Date: 29 October 2018

Report No: DPE-HUME-2018-2

From: Dr Ismet Canbulat

RE: Response to “Responses to reviews of the Hume Coal Project by Galvin and Associates, and Professor Ismet Canbulat”

Figure 18. Surface subsidence due to settlement of inelastic pillars

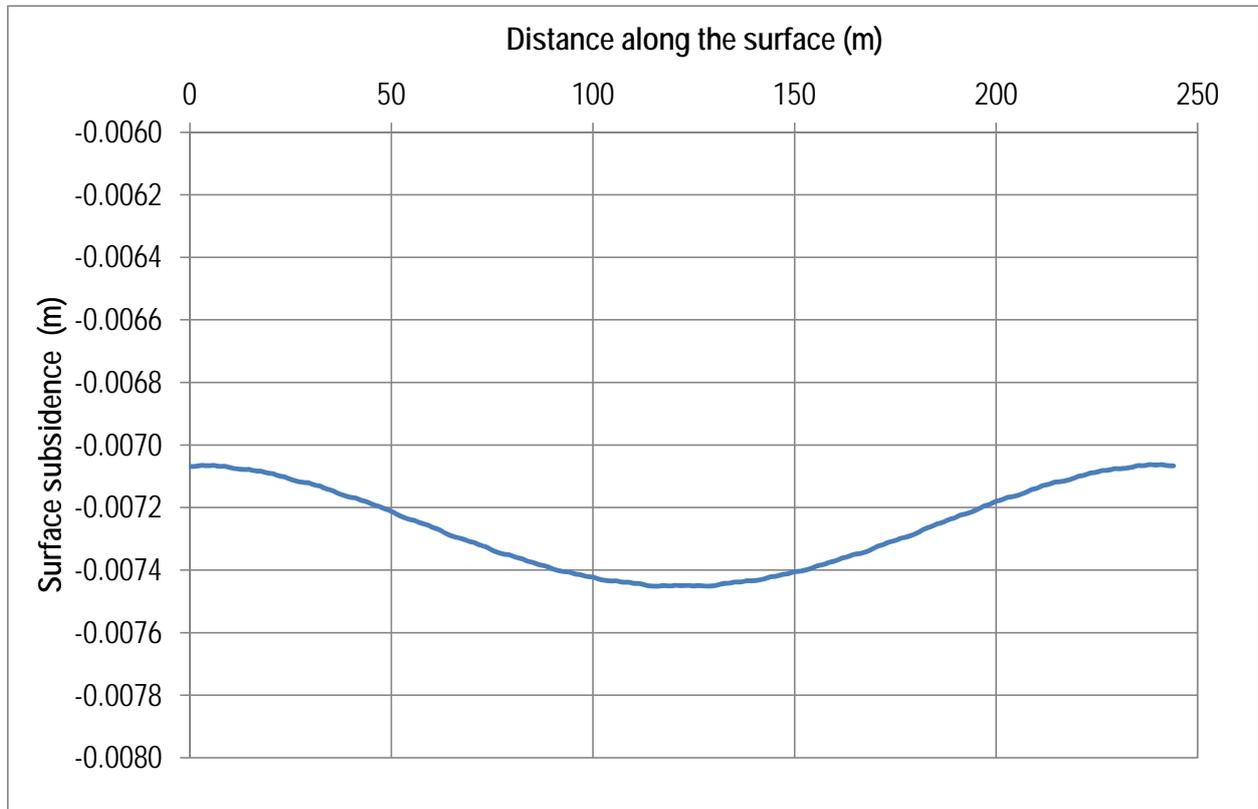
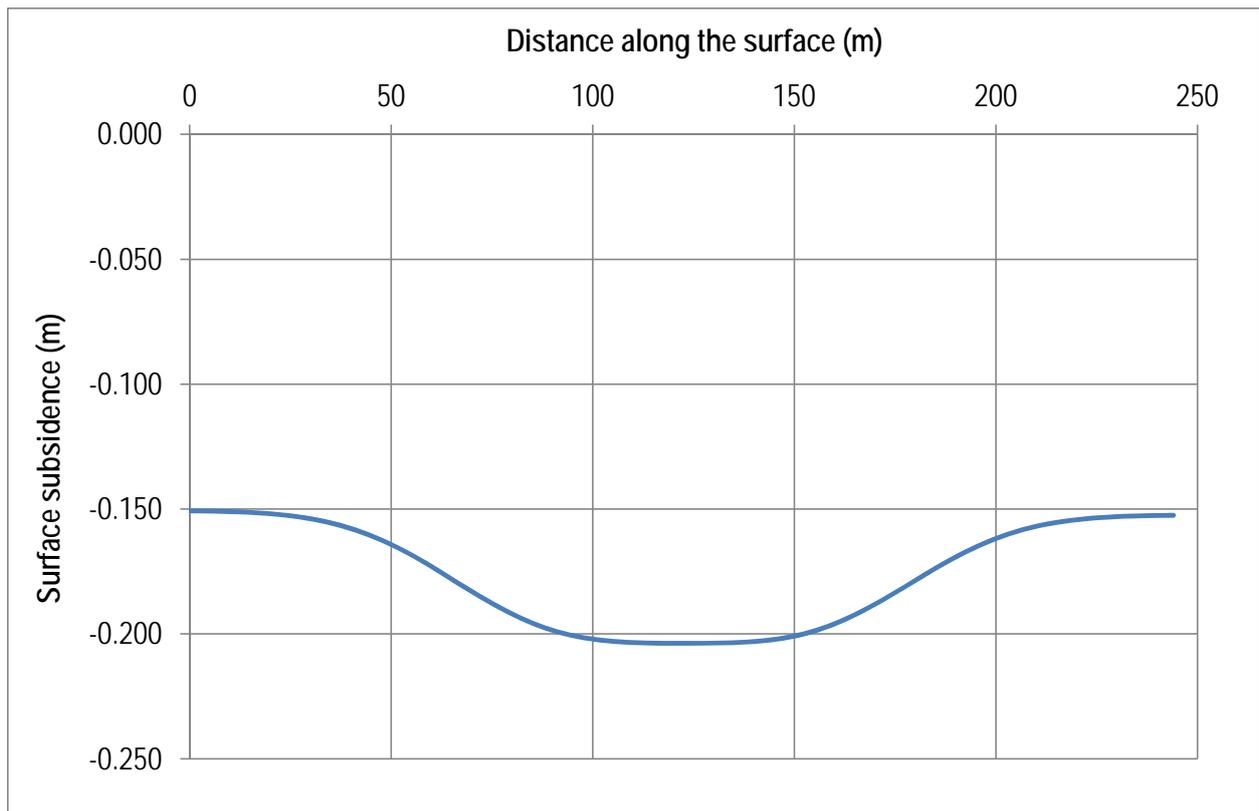
- Potentially conflicting results:** Figure 17 and Figure 18 were produced to indicate that when pillars go into an inelastic state, the subsidence can be higher than predicted by the elasticity theory. Therefore, Figure 18 can only be used for comparison purposes with Figure 17. On the other hand, Figure 24 represents the proposed layout with barrier pillars in-between the panels. Figure 18 and Figure 24 should not be compared as they do not represent the same layout.

Figure 21. Surface subsidence at 170m depth following the extraction of four panels

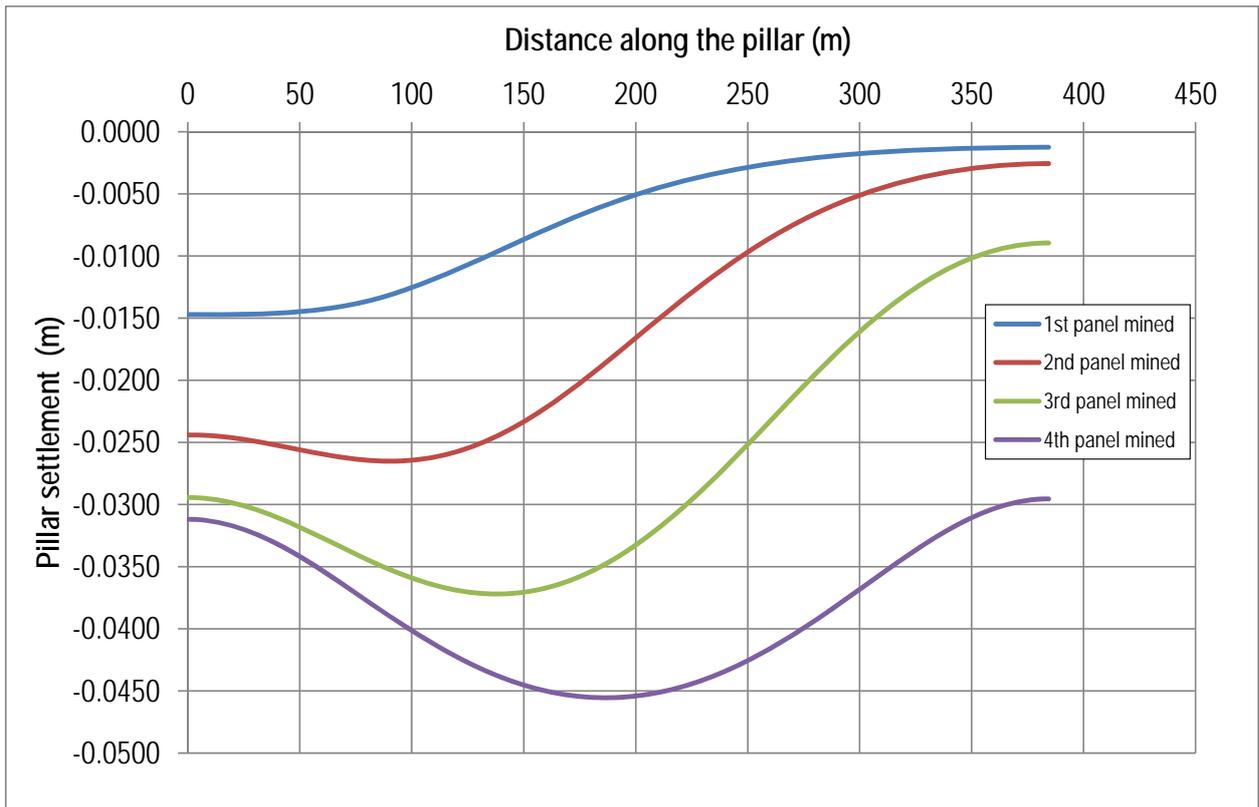
- **Anomalous results:** The title of the x-axis in Figure 21 should be distance along surface, which was correctly interpreted by Hume Coal. However, the interpretation of the results presented in Figures 21 and 22 are not

correct. This is due to the erroneous statement made in my previous report that the modelled layout was as shown in Figure 13. All layouts in Figures 19 to Figures 24 in my previous report contained 50m wide barrier pillars on either side with symmetrical boundaries (i.e., 100m wide barrier pillars) to isolate the four modelled panels. The extraction sequence was only same as provided in Figure 13. The web-pillar panel dimensions varied for different depths (as presented in Table 8), as stated in my previous report. The panels were mined in subsequent mining steps, resulting in non-symmetrical subsidence profiles in earlier panels which become symmetrical when the final, 4th panel is extracted. The purpose of these models was to demonstrate that in the case of web-pillars going into an inelastic state, the subsidence will increase as the number of panels increased. The modelled layout is shown in Figure 1 below. This should resolve most of the questions raised by Hume Coal in this section.
